Stonestreet Green Solar

Statement of Common Ground with the Environment Agency

PINS Ref: EN010135

Doc Ref. 8.3.2

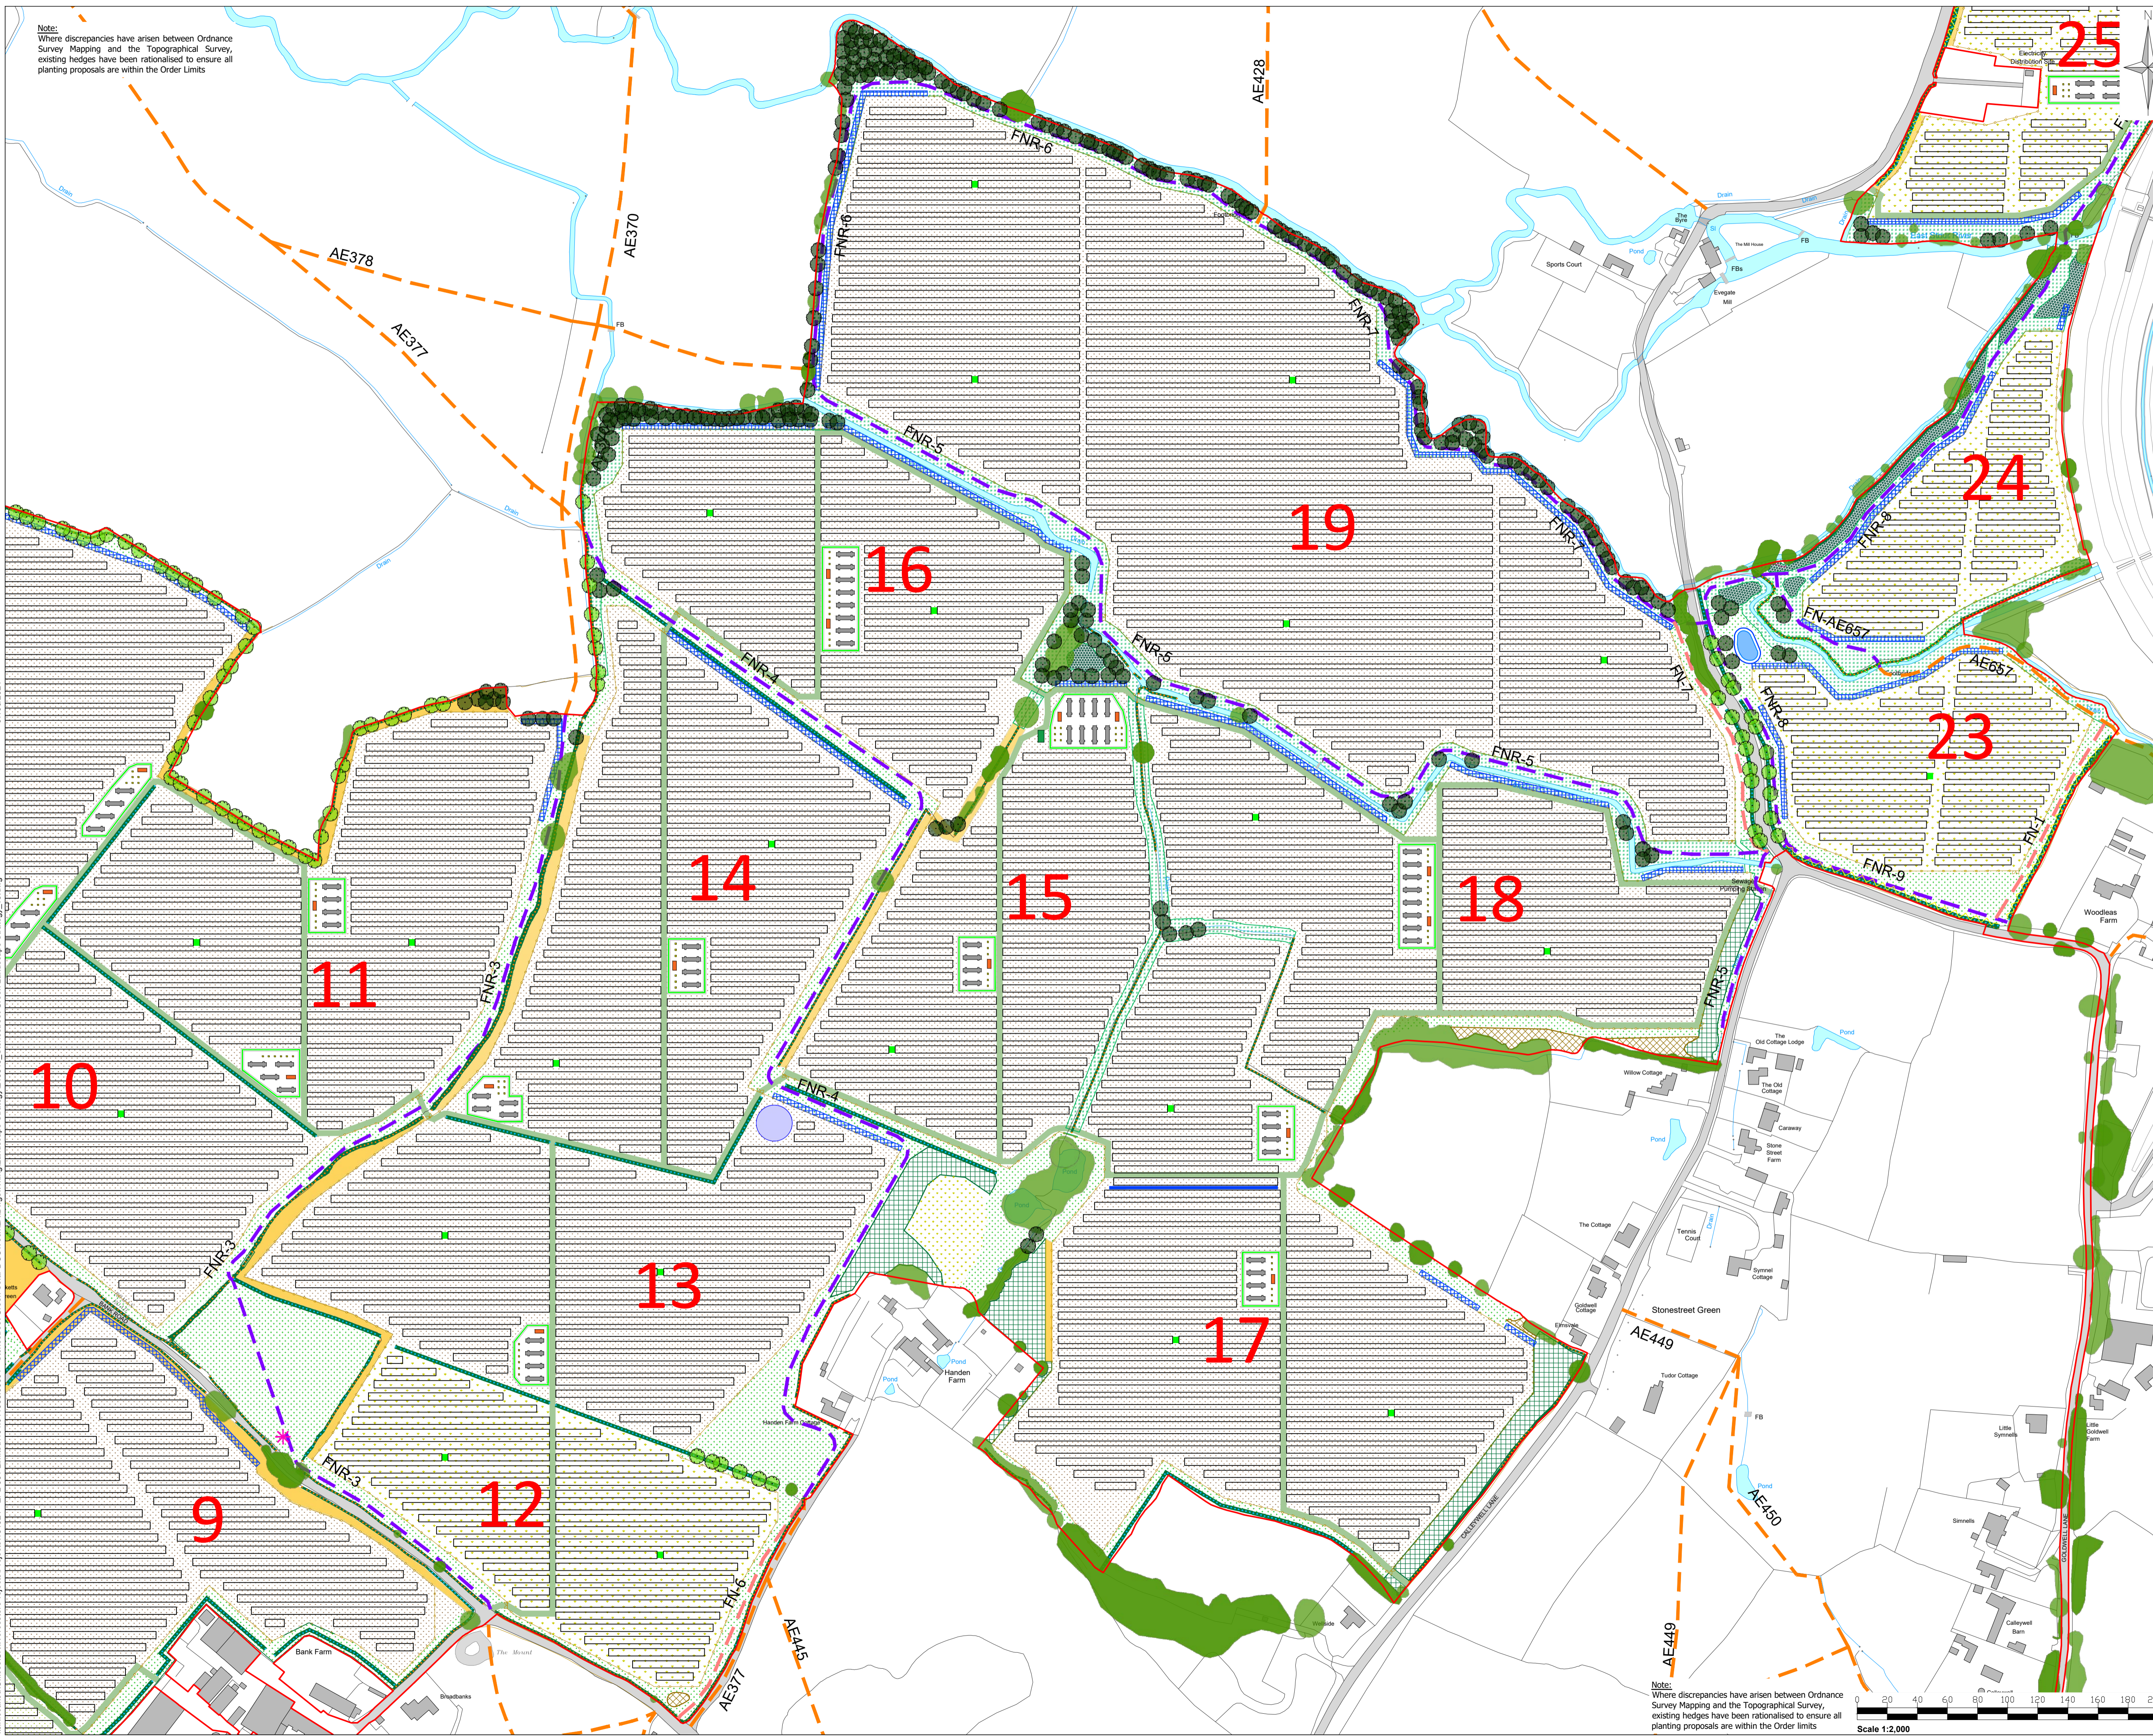
2.10 to 12	RR	Issue 3 - Flood Storage Calculations	<p>Situation: The 'Floodplain Compensation level for Level Calculation' table from 'Annex D: Floodplain Compensation Level for Level Calculations' of the FRA demonstrates a net increase (1,543.11 m3) in flood storage downstream of the Aldington Flood Storage Area but does not show any net increase within Aldington Flood Storage Area as referenced in the Outline Operational Surface Water Drainage Strategy (OOSWDS). Paragraph 5.1.5 of the OOSWDS states "The swale and wetland areas have both been designed to enhance biodiversity and ensure that there is no adverse impact on water quality. In addition, the wetland area, which will be sited within the AFSA, will increase the capacity of fluvial flood storage available. This will therefore contribute to a small reduction in downstream flood risk." (<i>APP-094 – Doc 5.4 Environmental Assessment</i>)</p>	<p>None of the works proposed within the AFSA involve any build up in ground levels.</p> <p>The works proposed relate to;</p> <ol style="list-style-type: none"> 1. Superficial treatments and vegetation management with a commitment made that vegetation management will be ongoing with any accumulated material removed from the AFSA. Such work would therefore have a neutral impact on flood storage, 2. The provision of fencing around the skylark area in Field 29 as illustrated on the Illustrative Landscape Drawings (Doc Ref. 2.7(A)) (Sheet 3 of 5 - drawing number 011998.00001.712). The fence posts would result in a negligible loss of flood storage, but at a level that would be difficult to quantify. 3. The creation of ecological scrapes and ponds as illustrated on the 	Under discussion

3.8 to 3.9	RR	Issue 9 - Tree planting	Situation: The landscaping proposals include the “planting of	Requirement 8 (Landscape and biodiversity) of Schedule 2 of the Draft	Under discussion

Ref	Relevant Application Document	Description of Matter	EA Current Position	Applicant's Current Position	Status
			<p><i>Appendix 10.2: Flood Risk Assessment; APP-159 – Doc 7.14 Outline Operational Surface Water Drainage Strategy)</i></p> <p>Impact: The storage capacity of Aldington Flood Storage Area may be reduced by the proposed landscaping works.</p> <p>Solution: The applicant should amend the flood storage calculations within the 'Floodplain Compensation level for Level Calculation' table from 'Annex D: Floodplain Compensation Level for Level Calculations' of the FRA to show the flood storage increase inside Aldington Flood Storage Area as stated in the paragraph 5.1.5 of the OOSWDS "increase the capacity of fluvial flood storage available".</p> <p>22/11/2024 (EA) As outlined above when the Outline OSWDS (Doc Ref. 7.14) is updated to include that there will be no net loss of storage capacity within the AFSA this will be conditioned. We have no further comments to make until we have reviewed the requested supporting calculations and updates to</p>	<p>Illustrative Landscape Drawings (Doc Ref. 2.7(A)) (Sheet 3 of 5 - drawing number 011998.00001.712). These would be formed by excavation only with all spoil removed disposed of outside of the AFSA. As such these works would only increase the available flood storage volume.</p> <p>4. The creation of the wetland area which will receive storm runoff from the Project Substation. This will be formed by excavation and will not involve impounding water to a level above the existing ground surfaces. As such the formation of this feature can only increase the volume of flood storage available.</p> <p>The net effect of these works will clearly be an increase in the available flood storage volume within the AFSA. On this basis no further assessment was deemed necessary.</p> <p>In response to this comment work is however now being undertaken to quantify the changes resulting from items 2, 3 and 4 above. This additional detail will be included within Environmental Statement Appendix</p>

Ref	Relevant Application Document	Description of Matter	EA Current Position	Applicant's Current Position	Status
			Environmental Statement Appendix 10.2: Flood Risk Assessment (Doc Ref 5.4)	10.2: Flood Risk Assessment (Doc Ref 5.4(A)). The updated document will be provided by Deadline 1. In addition, the Applicant will also amend the Outline OSWDS (Doc Ref. 7.14(A)) to include a commitment to ensure no net loss of storage capacity within the AFSA.
